From:  Simon Davis
Sent: 14 November 2014 13:23
To: 'M NORRELL'
Subject: Woodgate Farm, Westergate Street, Aldingbourne - Ref AL/75/14/OUT
Attachments: e25437fda57a457.pdf

I am the case officer for your application. Having now had chance to properly analyse the application, I am of the view that 3 houses is too much. My reasoning is that the current scheme fails to comply with Councils space standards policies as set out in the emerging Local Plan (Policies D DM2 & D DM3). You can view these in this part of the emerging Local Plan:

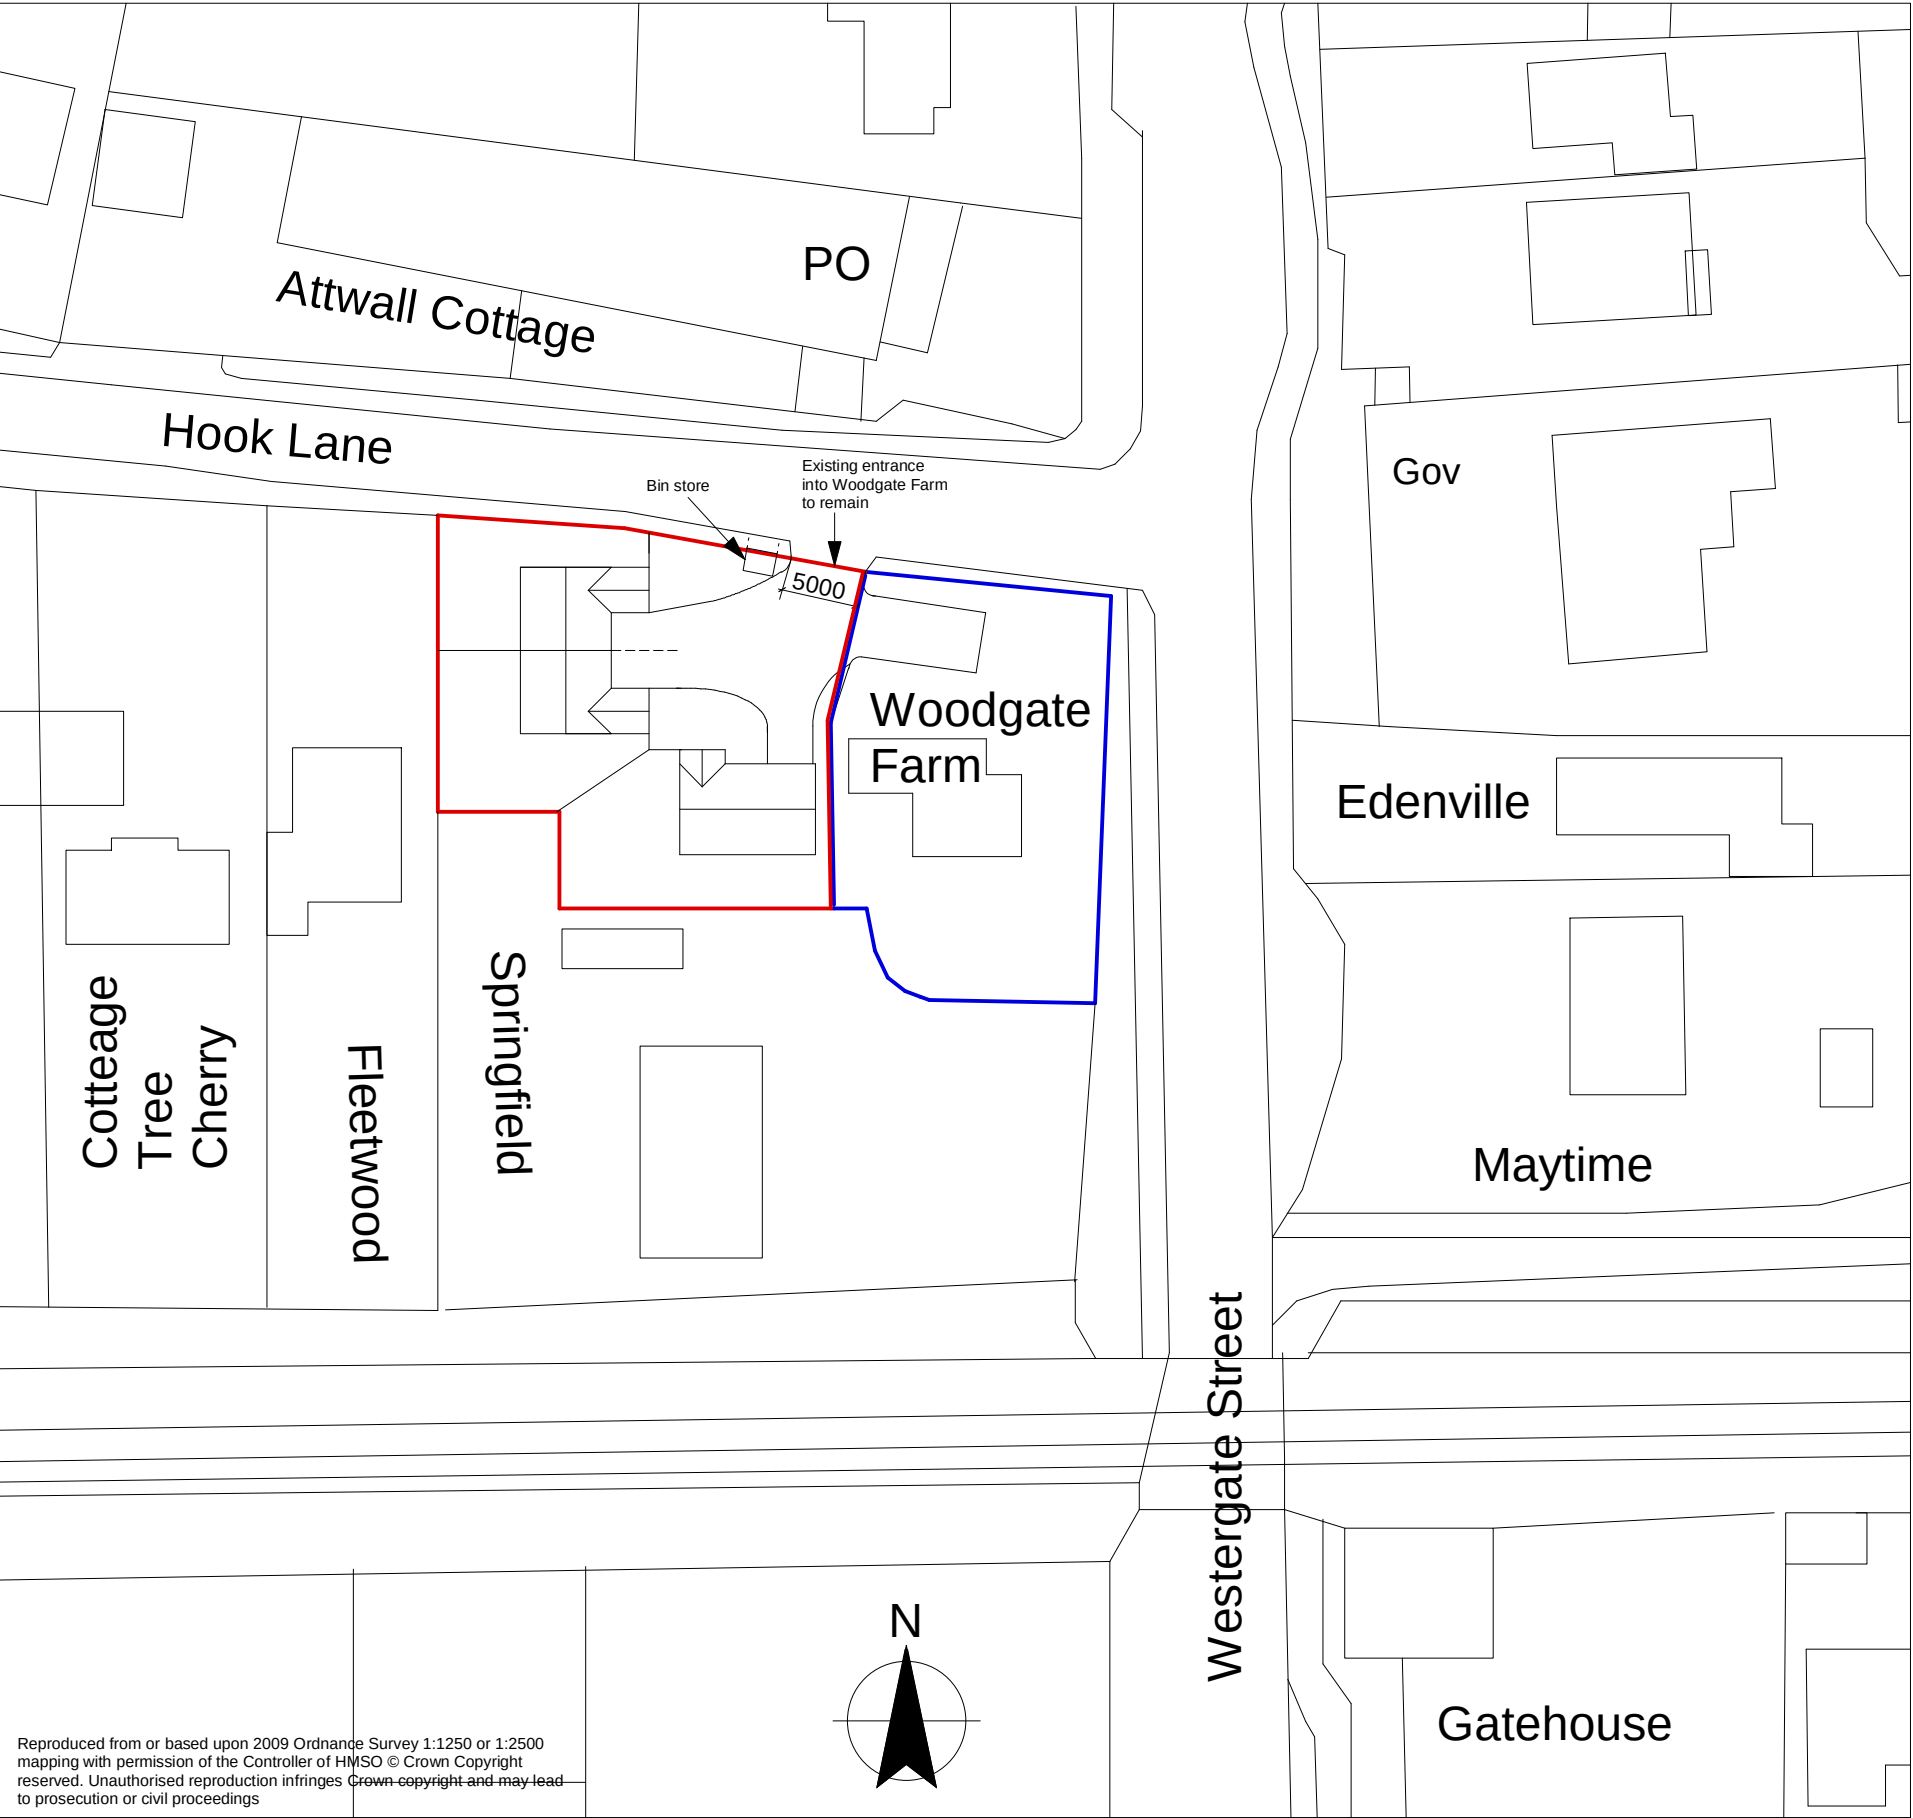
I consider that the dwellings will not comply with either the internal space standards or the external space standards and I am also concerned as to how much garden Woodgate Farm is left with. I appreciate that the site layout is only indicative at this stage but I don't believe that 3 houses can be accommodated whilst adhering to our policies. If you can agree to change the description to 2 then I will be able to recommend approval, otherwise it will have to be a refusal. Please note that I won't need a new indicative layout, just your client's agreement to the amended description. I also won't need to re-consult neighbours/consultees. However, regardless of the recommendation, I won't be able to determine this by the 17th December but I will send an Extension of Time request to you separately to cover that aspect.

Please find the signed extension request form and I can confirm that my client and applicant Mr & Mrs Horsman are in agreement to change the description form 3 to 2 units and amend the application description.

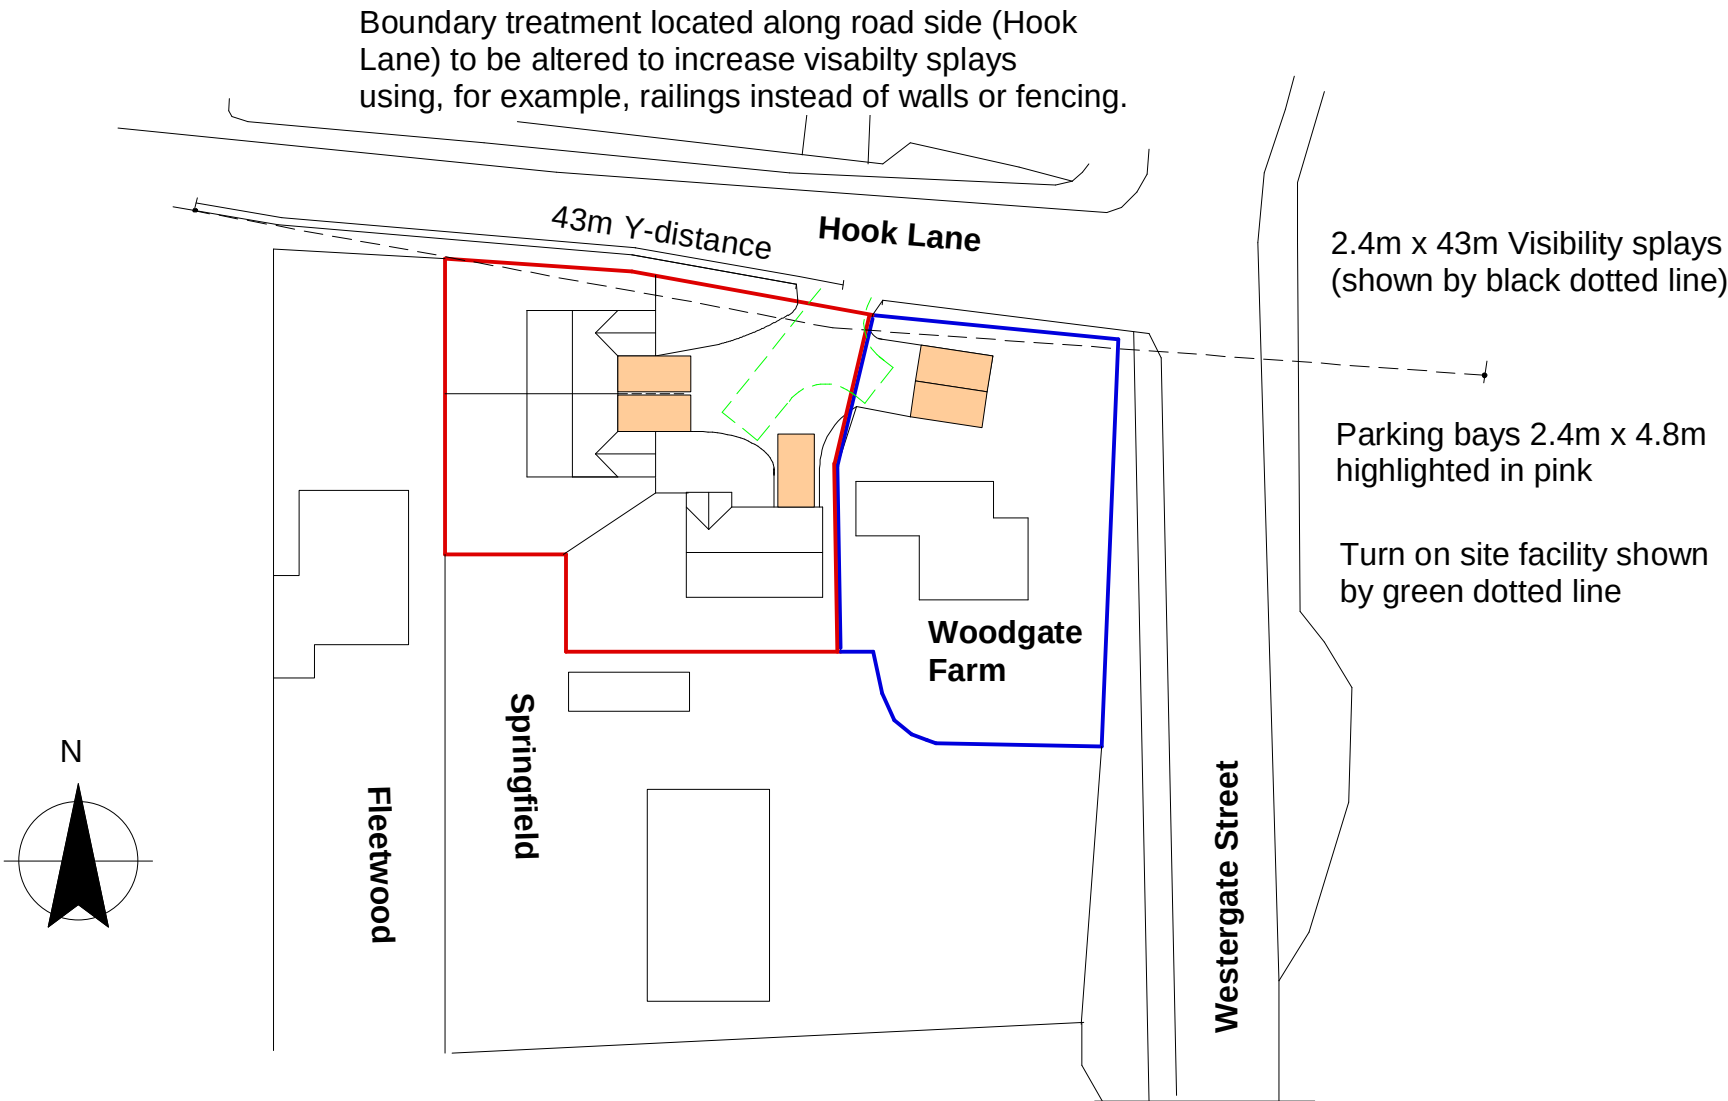
Re parking, when I used the calculator, I got a demand of 6 spaces but either way, they are short and this would lead to increased street parking possibly to the detriment of the Hook Lane/Westergate Street junction. Ultimately, the not being able to provide enough parking suggests overdevelopment.

Please find attached drawing number DH02vA that addresses the points raised in the consultation response letter from WSCC Highways.
